Our Ref: 2023/90198
Date: 16-Mar-2023

**TOWN AND COUNTRY PLANNING ACT 1990
TOWN AND COUNTRY PLANNING (GENERAL PERMITTED DEVELOPMENT)
(ENGLAND) ORDER 2015 - APPLICATION NO:2023/N /90198/E
DEVELOPMENT: PRIOR NOTIFICATION FOR PROPOSED 5G TELECOMS
INSTALLATION: H3G 15M STREET POLE AND ADDITIONAL EQUIPMENT
CABINETS WEST PARK ROAD, HEALEY, BATLEY, WF17 7EN**

The proposal is not acceptable to the Council, and notice is hereby given that the details submitted have been refused.

215 PROPOSED SITE PLAN

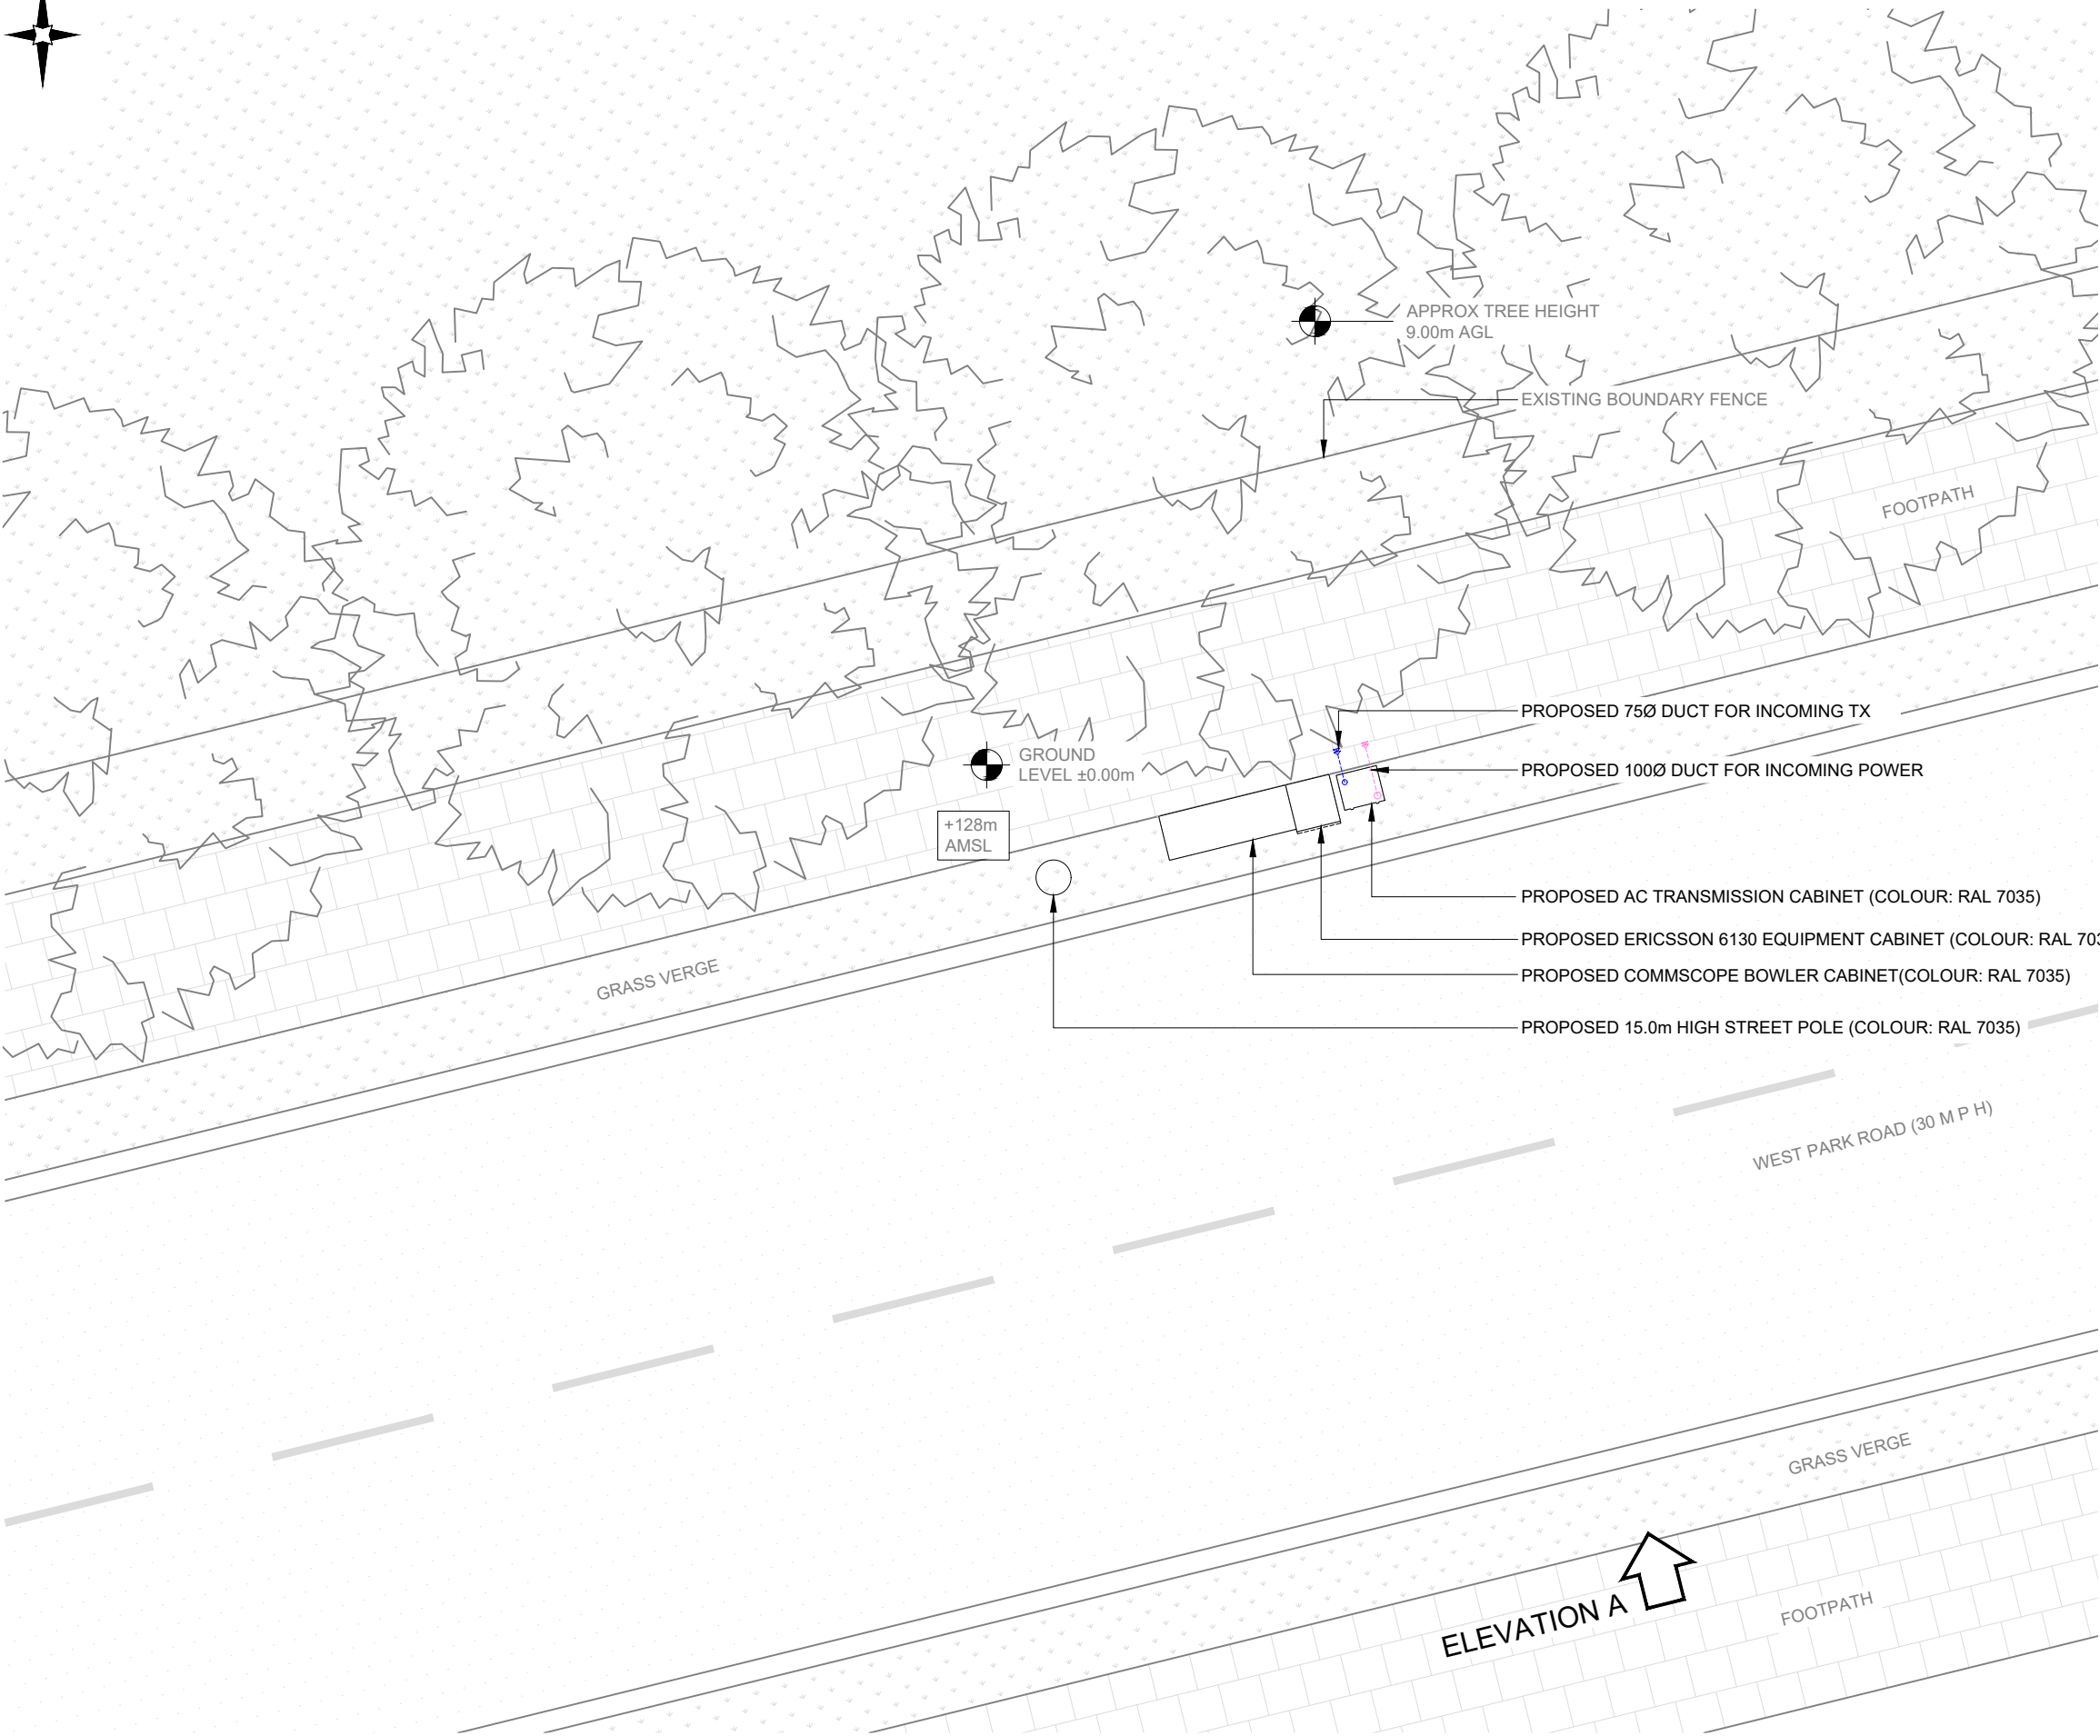
The proposed location within the grass verge is unlikely to be supported by the Highway Authority by reason of the close proximity to the kerb. Consequently, insufficient detail has been provided to assess the proposals potential impact to the Highway and is therefore contrary policy LP21 of the Kirklees Local Plan.

Title:
265 PROPOSED SITE ELEVATION

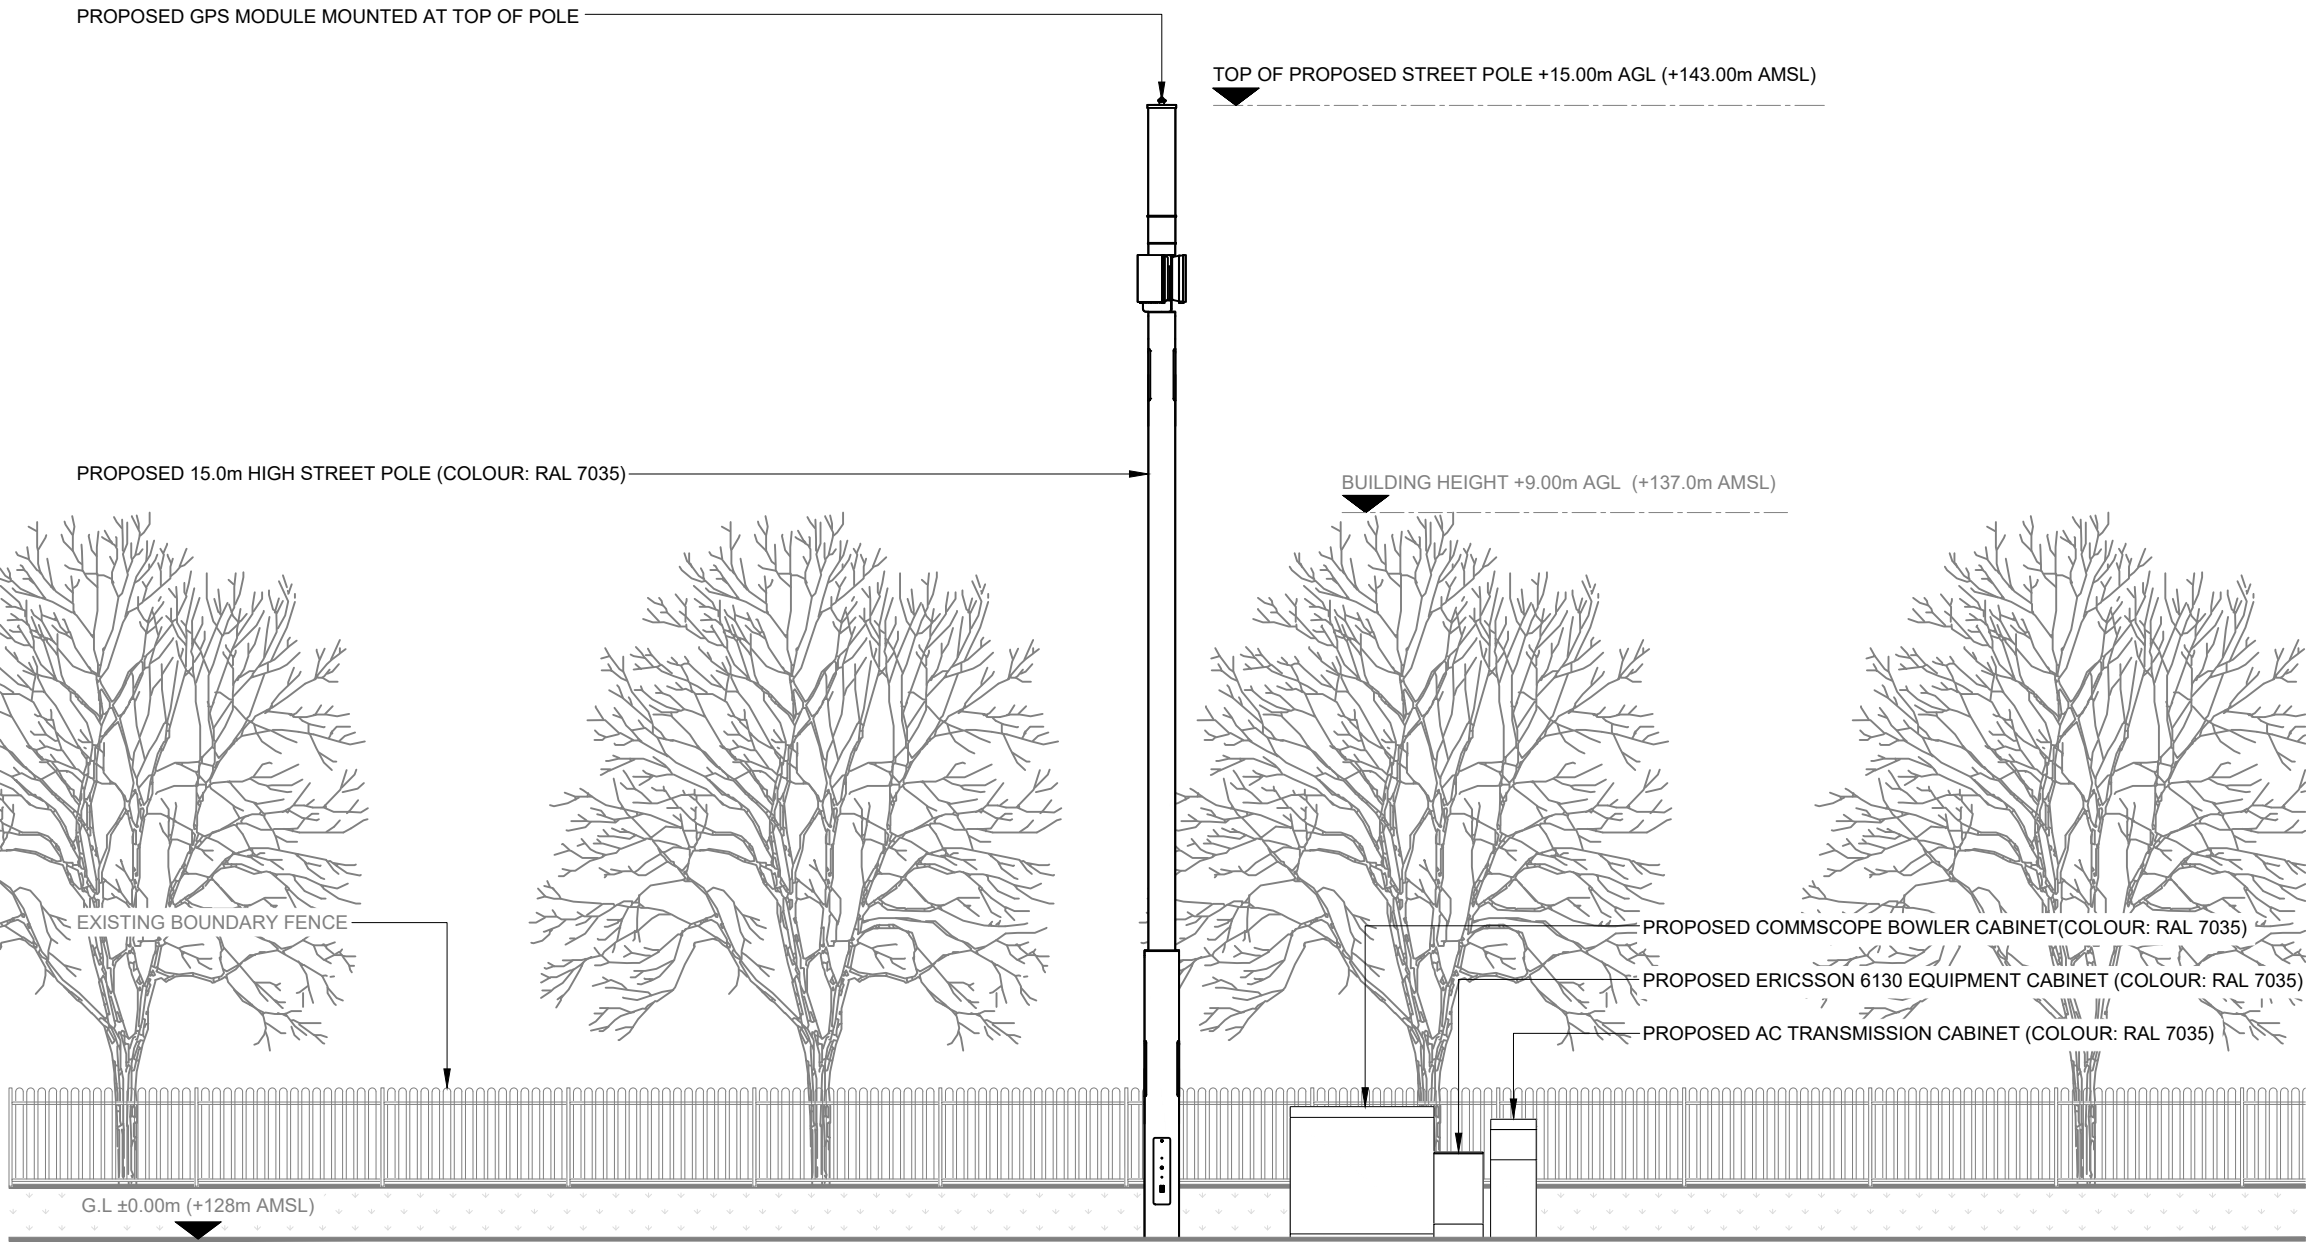
The proposed mast, by reason of its siting, overall height and appearance, would introduce a visually intrusive and incongruous feature within the street scene, appearing out of scale with the surrounding development and failing to respect the open character of the streetscape and wider area. This harm is not outweighed by the benefit of quality telecommunication infrastructure as the applicant has not fully demonstrated the mast and equipment could not be located at a more suitable site within the vicinity of the proposed location. The proposed development would be contrary to policy LP24 of the Kirklees Local Plan and Chapters 10 & 12 of the National Planning Policy Framework.
